**RE: M-51 Industrial– Response to 2nd Technical Review Comments
Project No. PA 23014**

Please refer to our responses below which address all review comments received from the City of Marysville on May 24th, 2024, regarding the M-51 Industrial resubmittal submittal package. You will find the markup comments listed in the order that they were written followed by our response in *italics*.

REFERENCE LINE
SEE SHEET RD-01

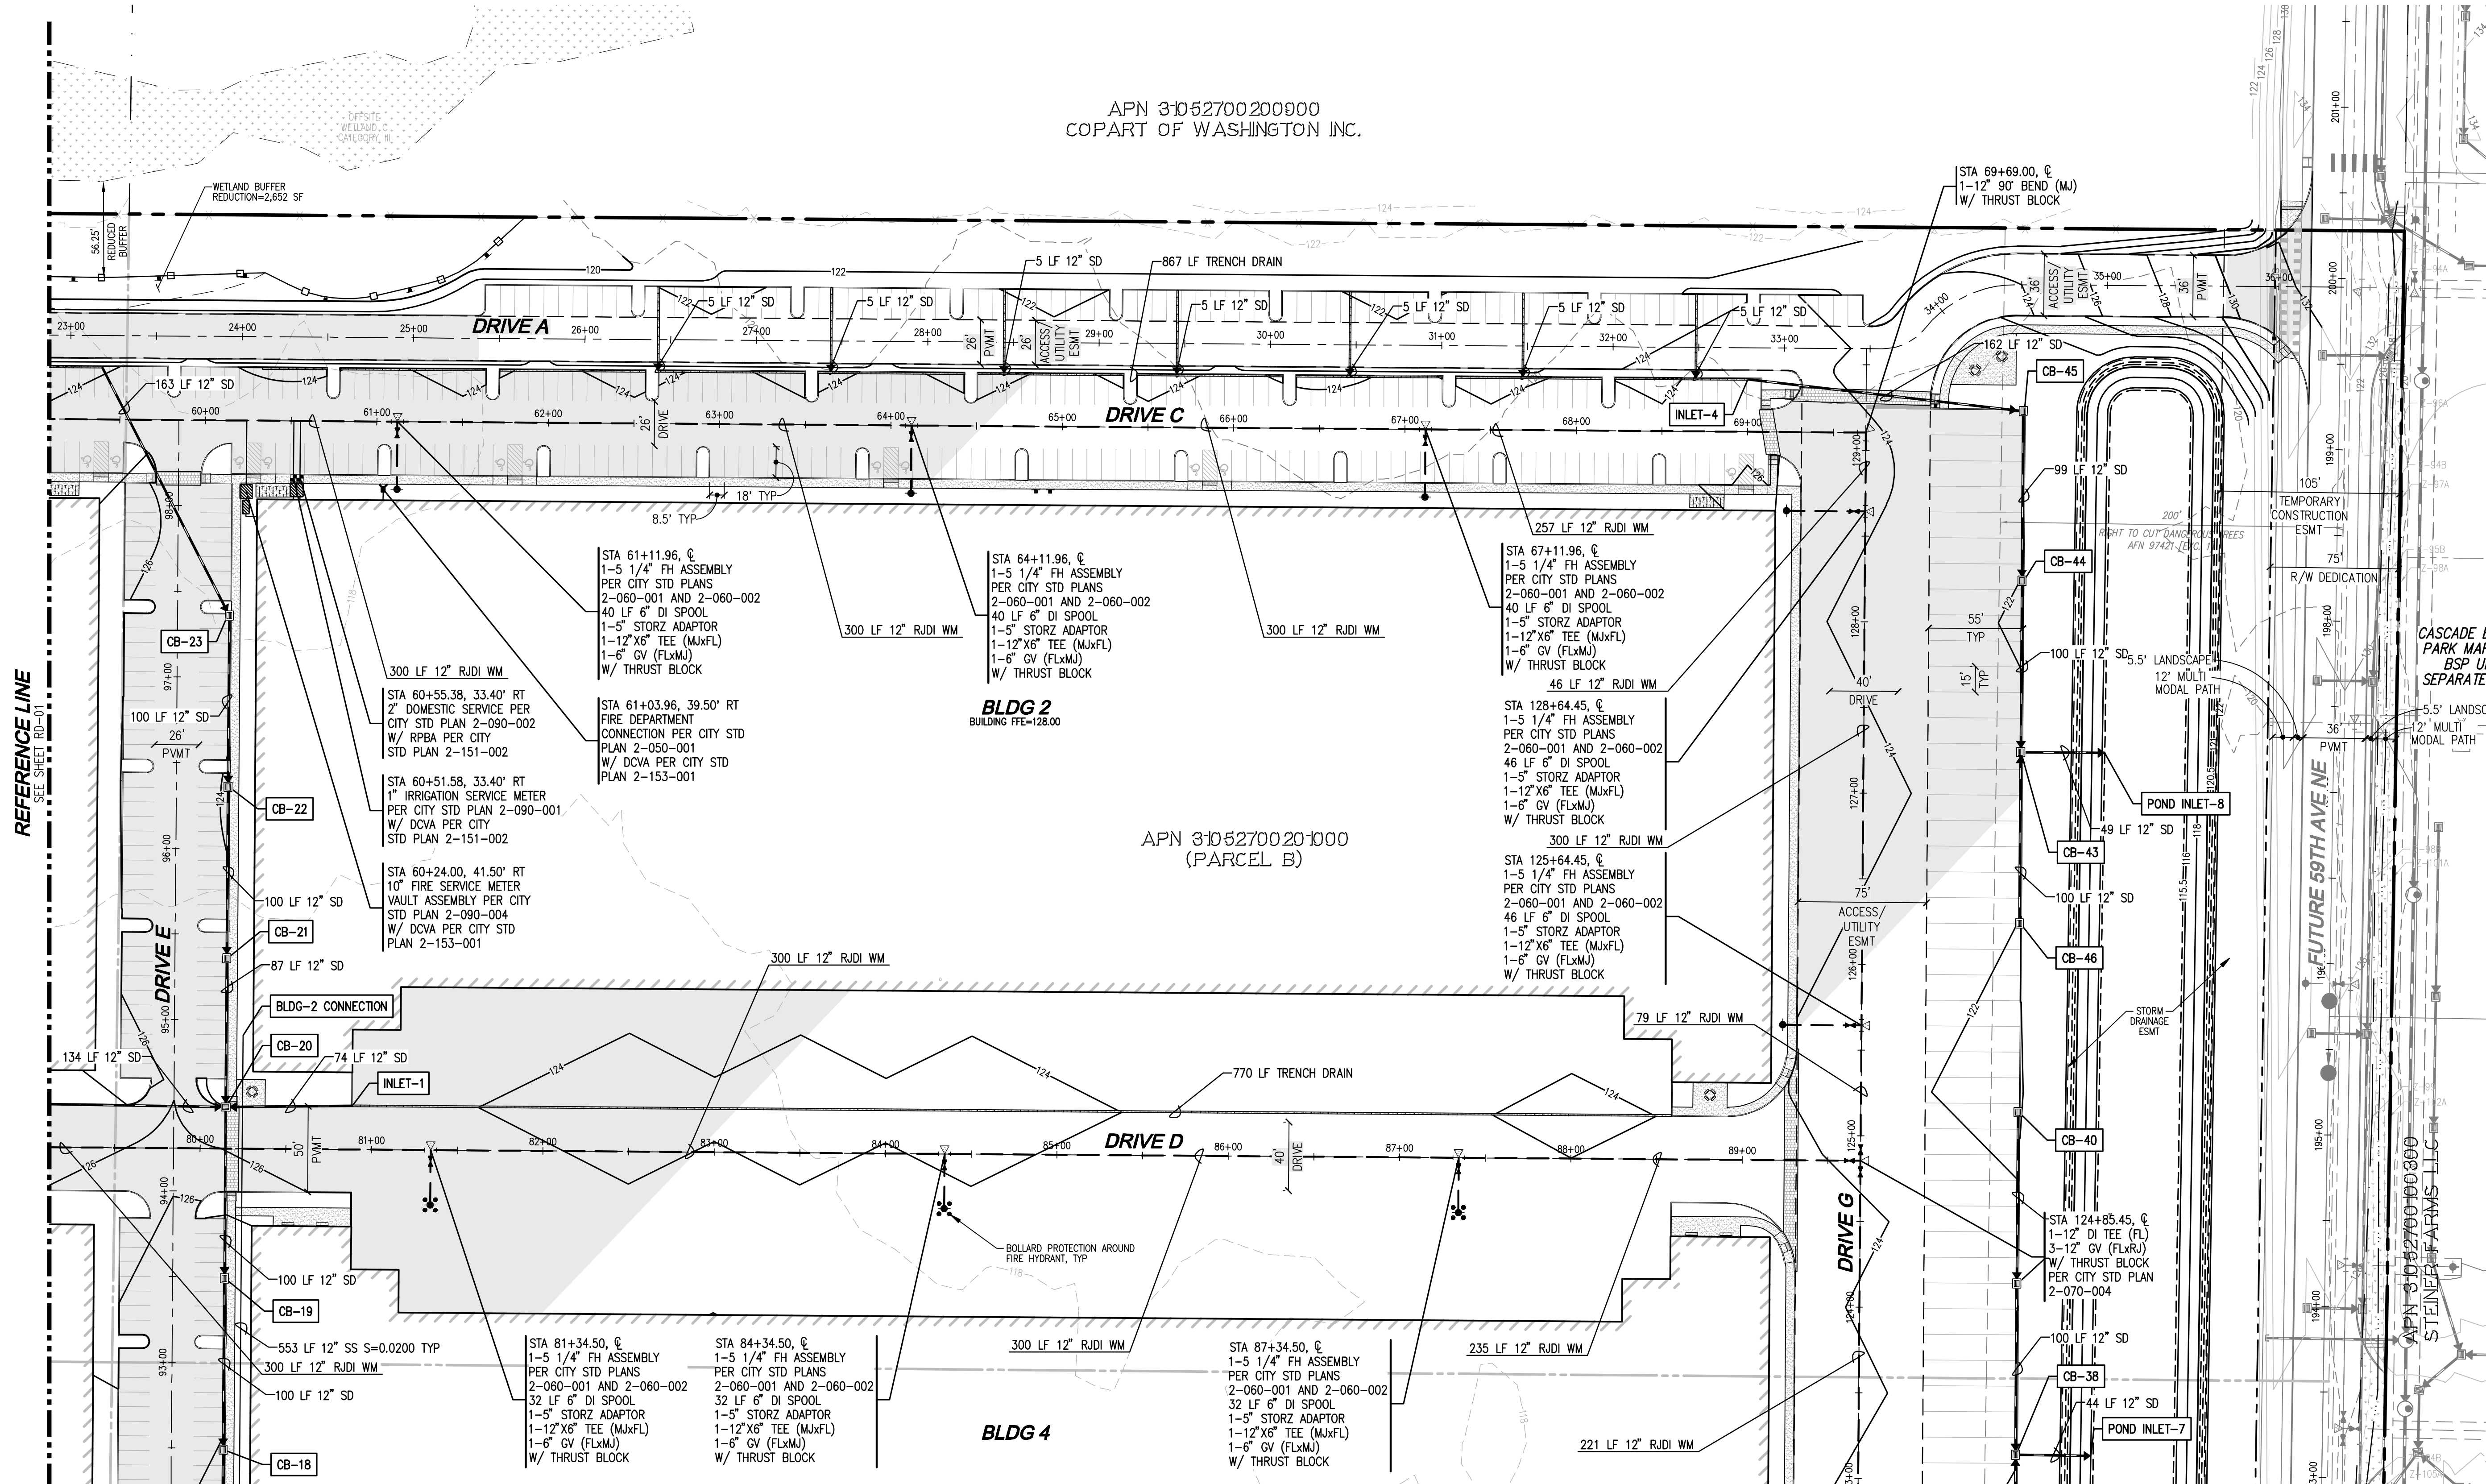
- e. **TR1 Comment:** Provide a detail, and top and toe height of all proposed walls, including the proposed wall around APN 31052700200800.

TR2 Comment: Wall information not found in the plan set.

Response: The wall design was changed as shown on RD-01 (Sheet 12) with detail on DT-03 (Sheet 43) and in the Landscape plans.
